Subject: EP/3/22/PL: Change of temporary outside seating area to the rear of the restaurant to be a permanent seating area for the consumption of food and beverages for our customers to use all year round.

Environmental Health:

Client: Mr R Aru	
Project Address: Ristorante al Mare 2 The Street East Preston BN16 1JJ	
Drawing Title: Existing and Proposed Plans and Site Block Plan	
Drawing Number: 1262.01	
Scale:	As stated printed @ A1
Date:	17/06/2020

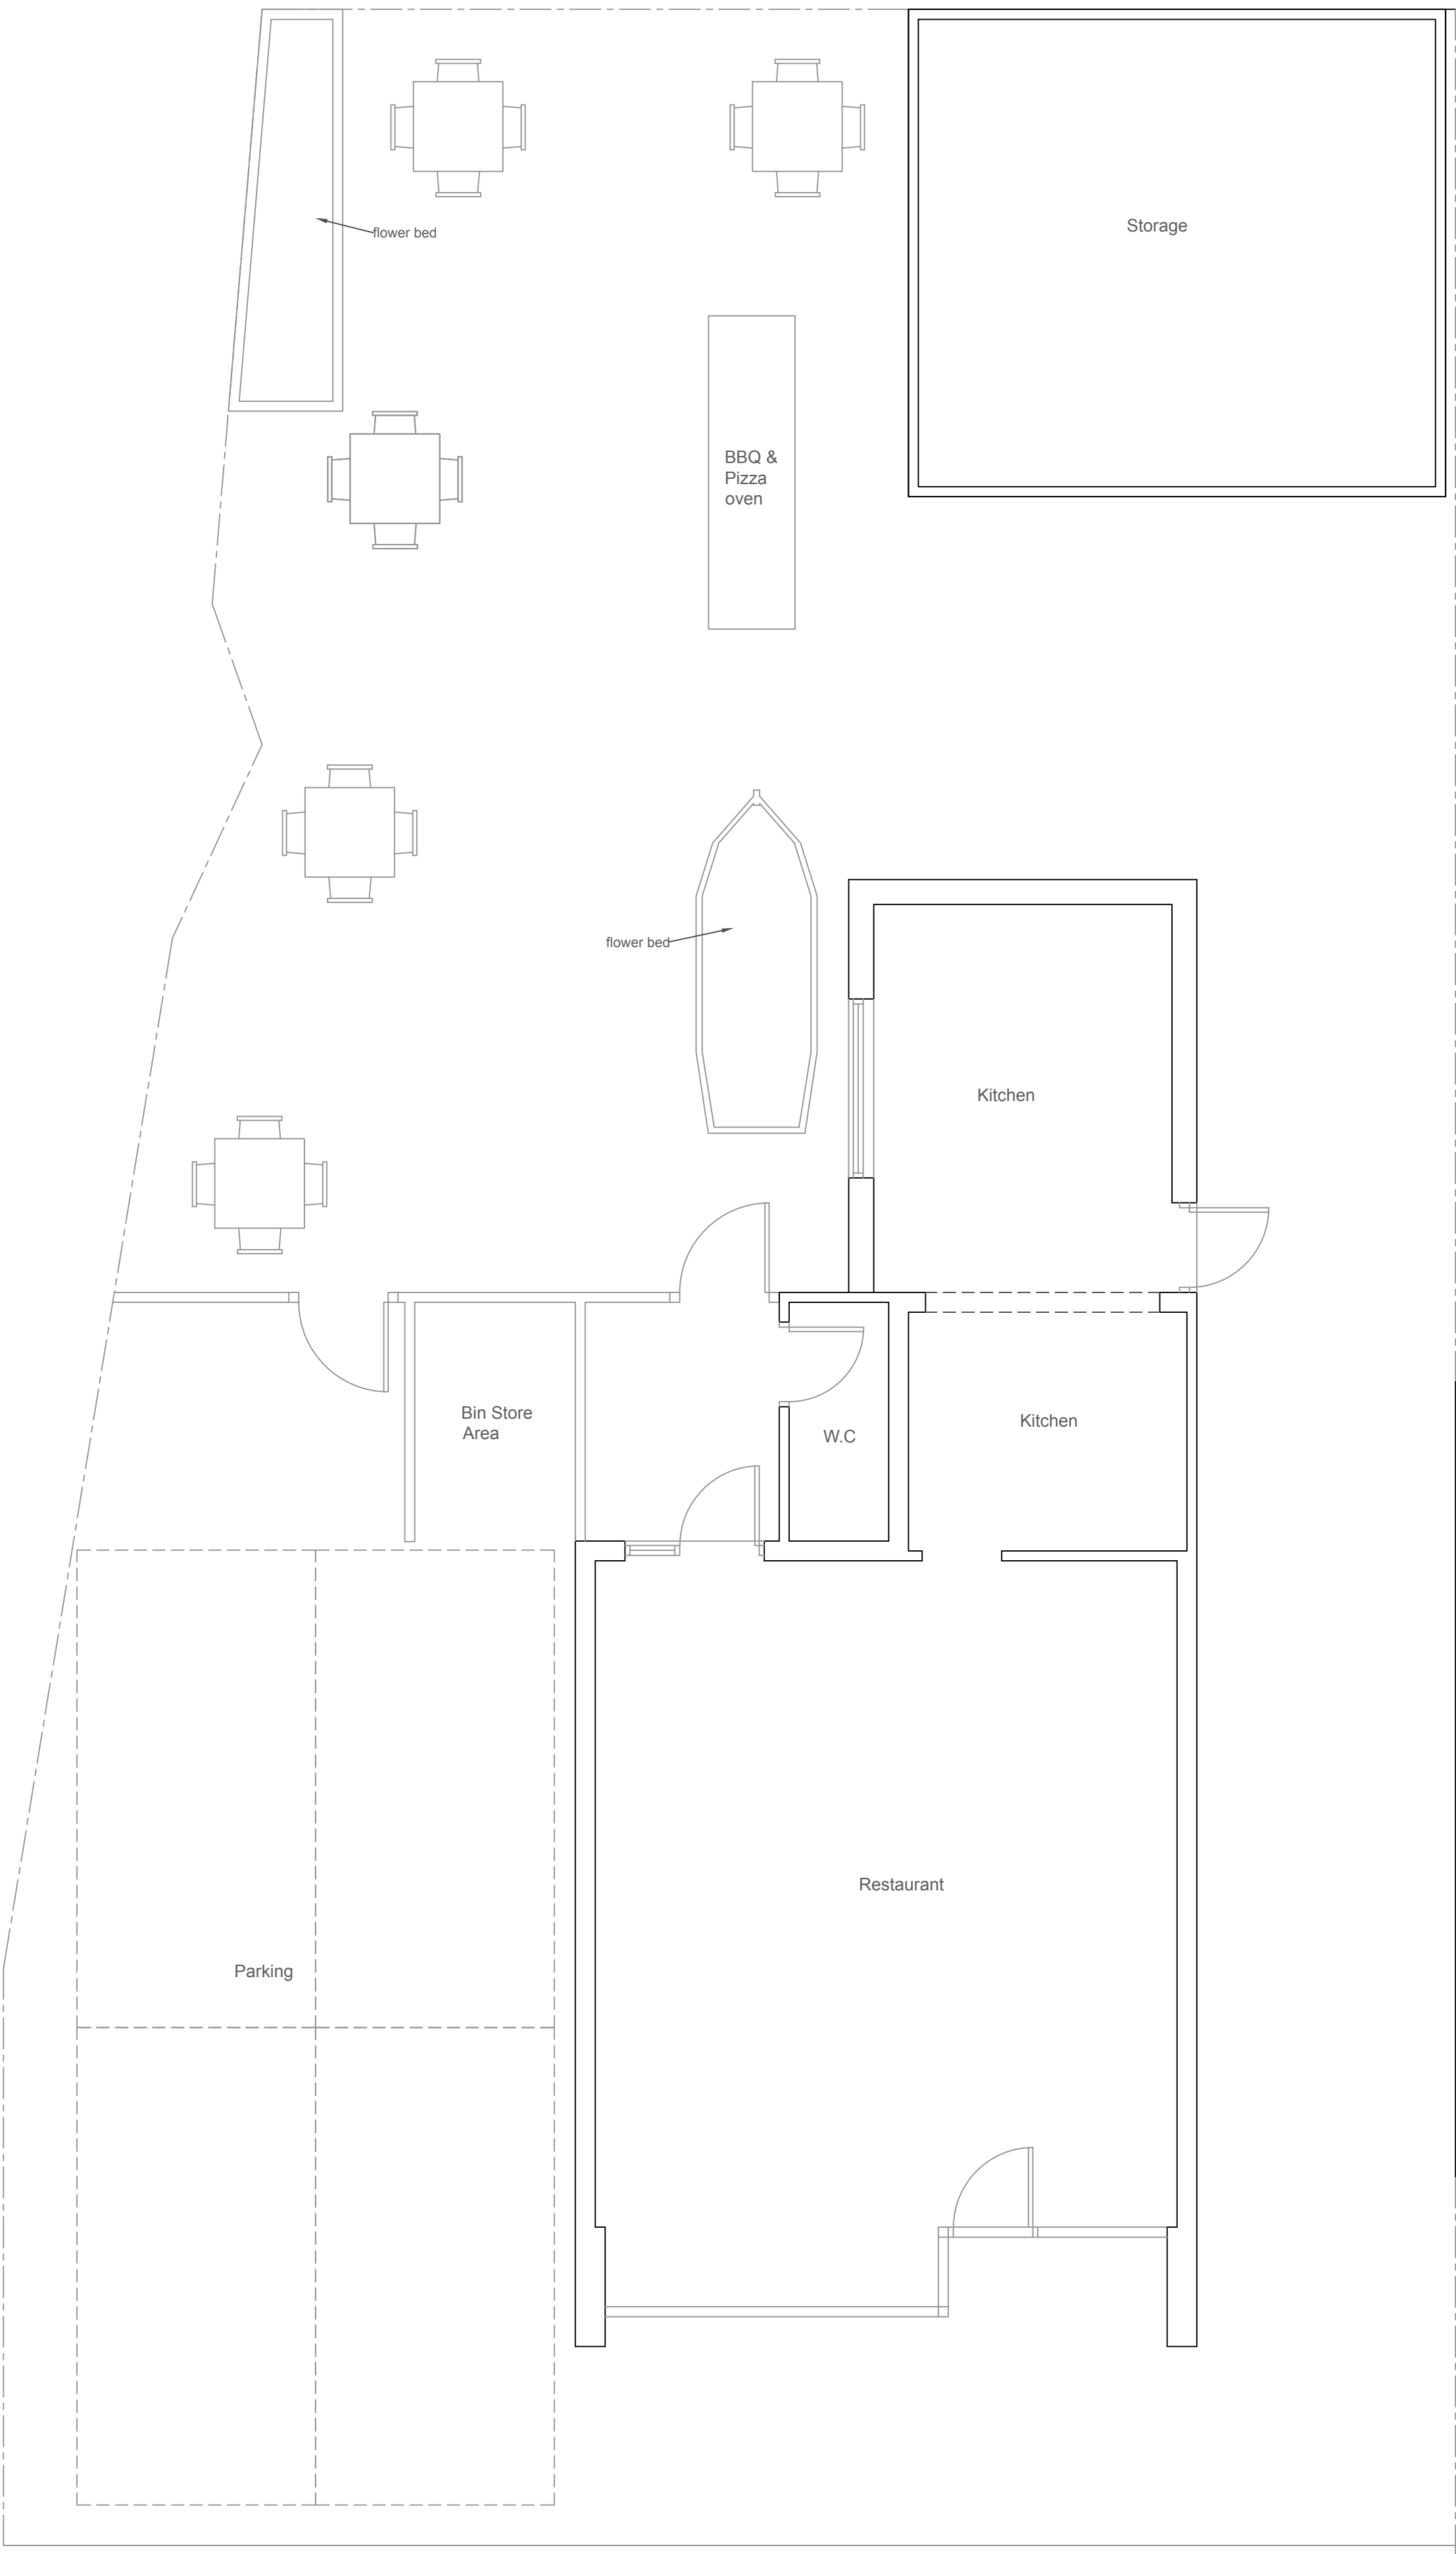
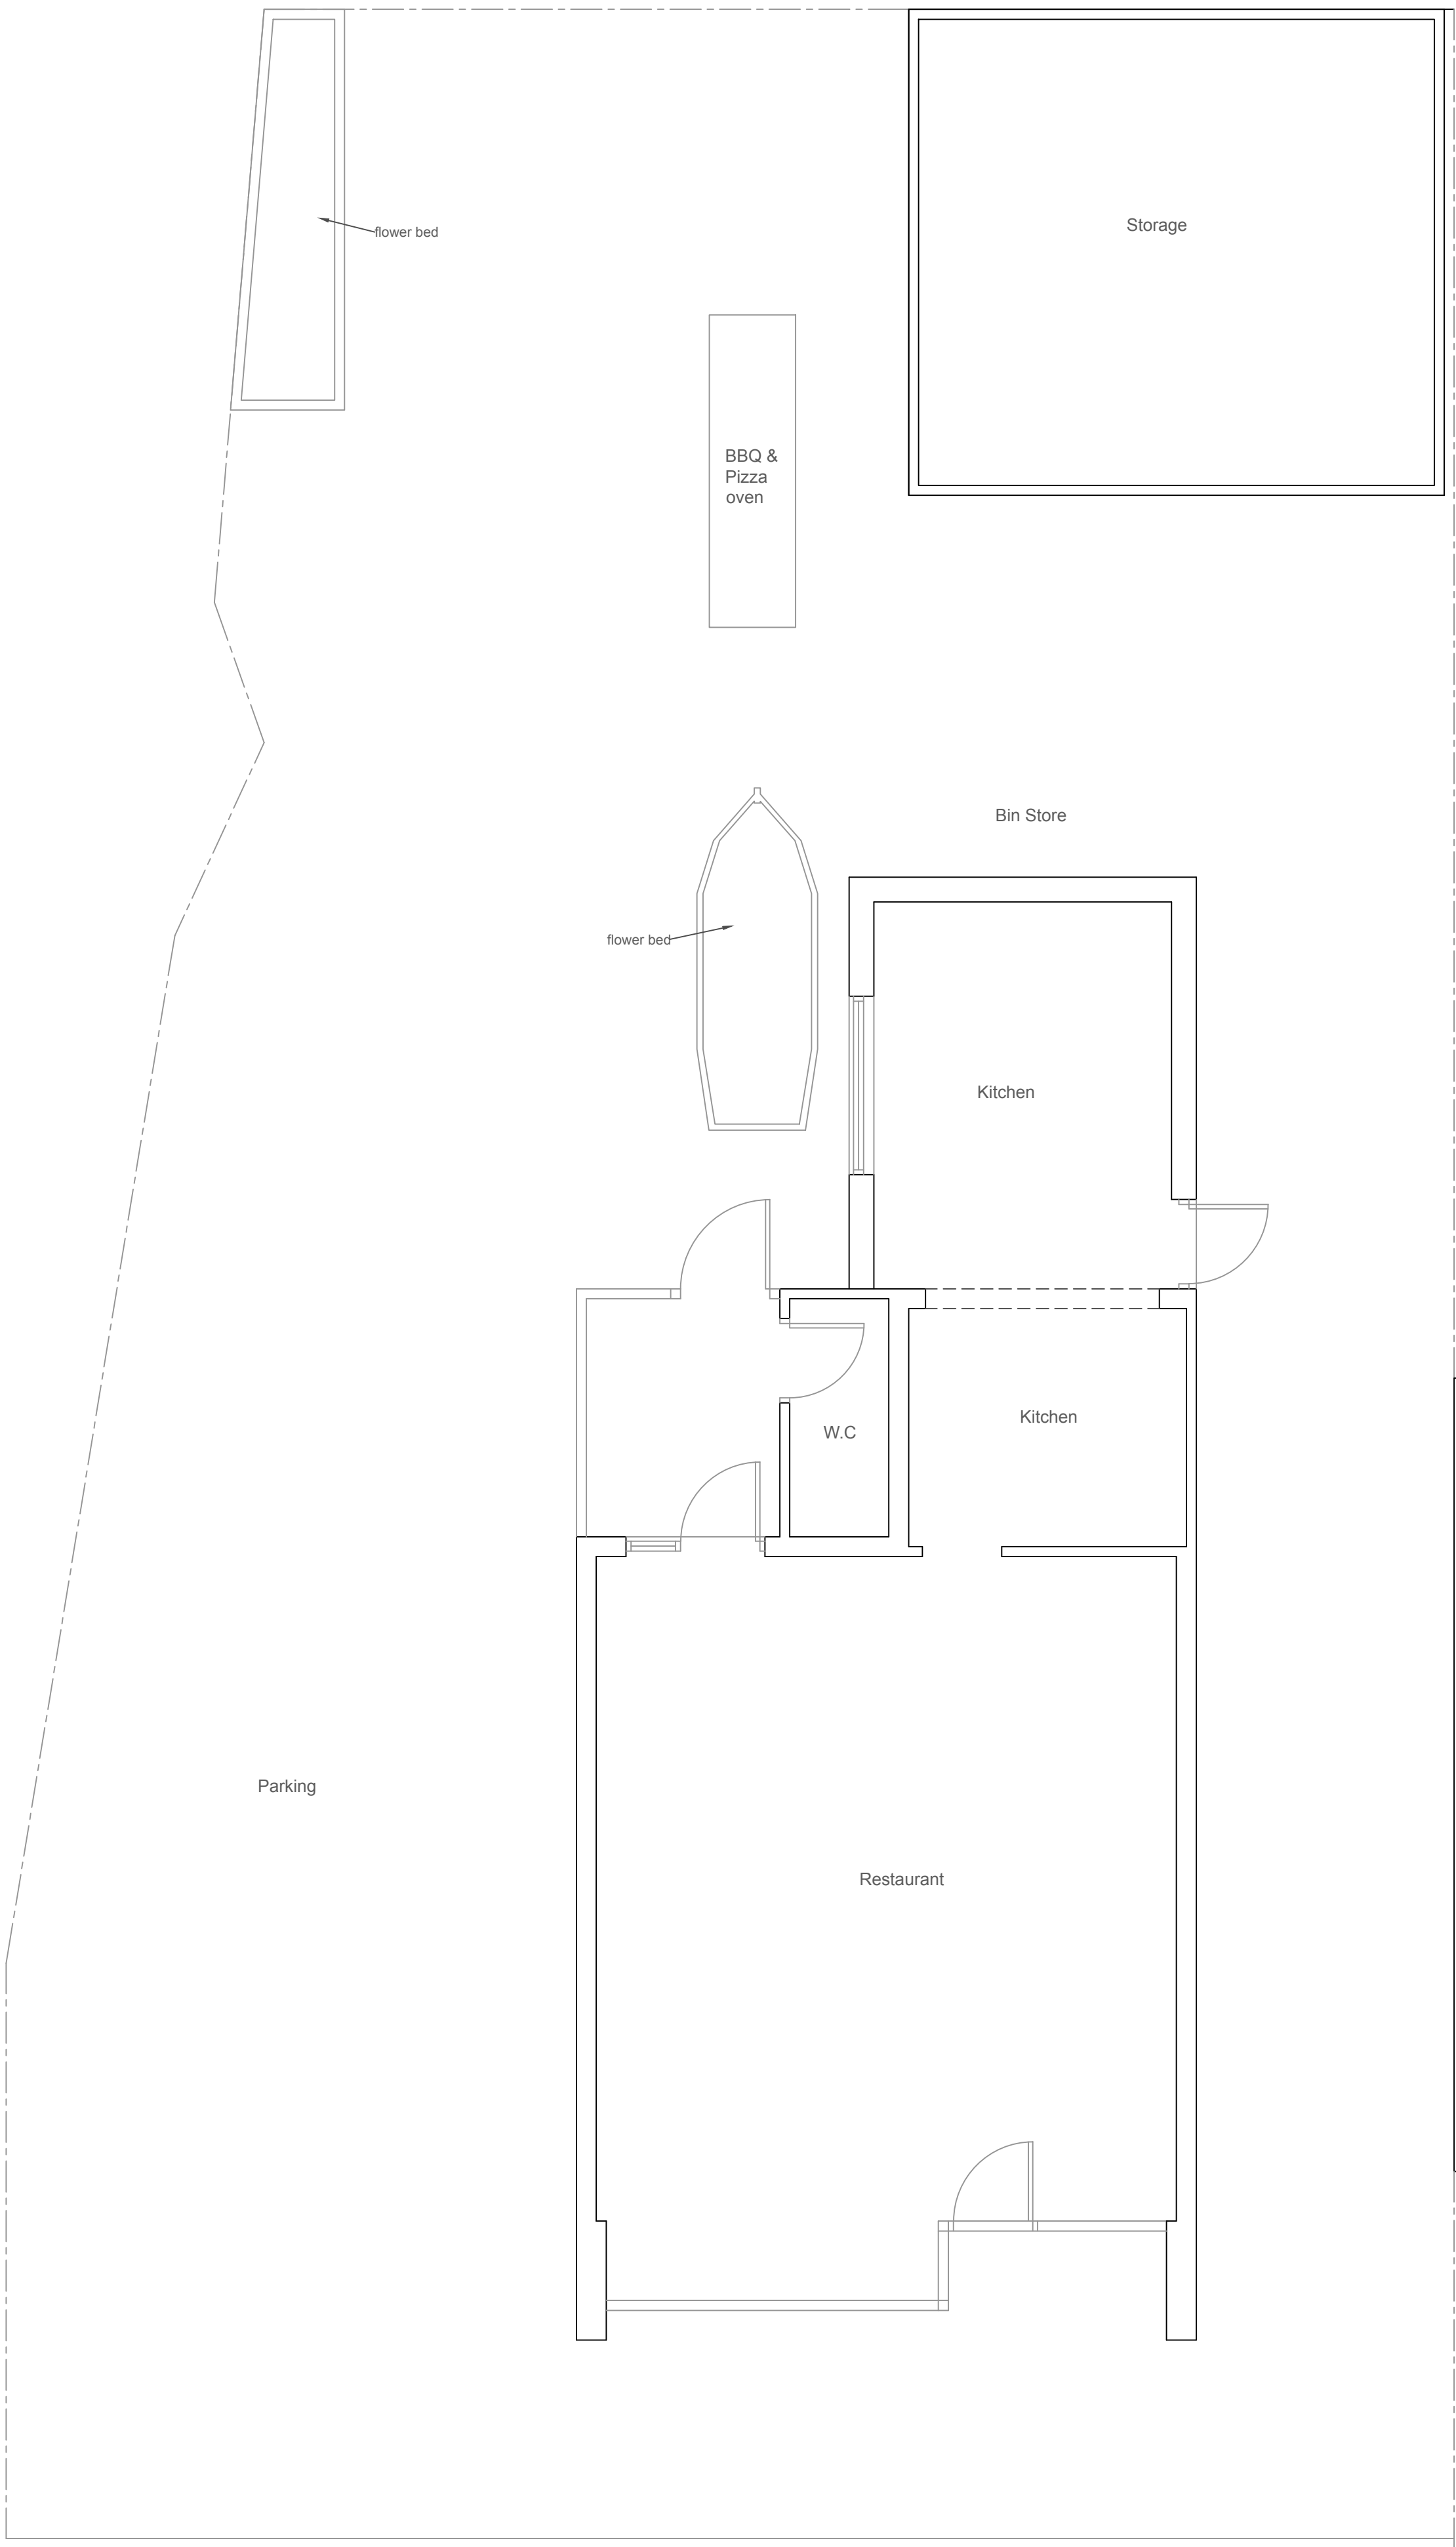
It is noted that the current application, as opposed to Planning Application EP/60/20/PL makes no reference to the outside Barbeque and Pizza Oven which remain in place despite the Condition that the site should be returned to its previous condition, on or before the end of the trial period 12 February 2021. It would be reasonable to infer that such outdoor cooking facilities would be brought into use should the current Planning Application be granted. I consider such use as likely to cause odour detriment which will restrict the reasonable use of neighbouring properties. The fact that there is a garage immediately behind this equipment on the restaurant site, will serve to limit dissipation of odour, fumes, etc in this case.

This application also seeks to increase the provision of outside lighting in order to facilitate the proposed use. This again has potential to be detrimental to the amenity of nearby sensitive receptors.
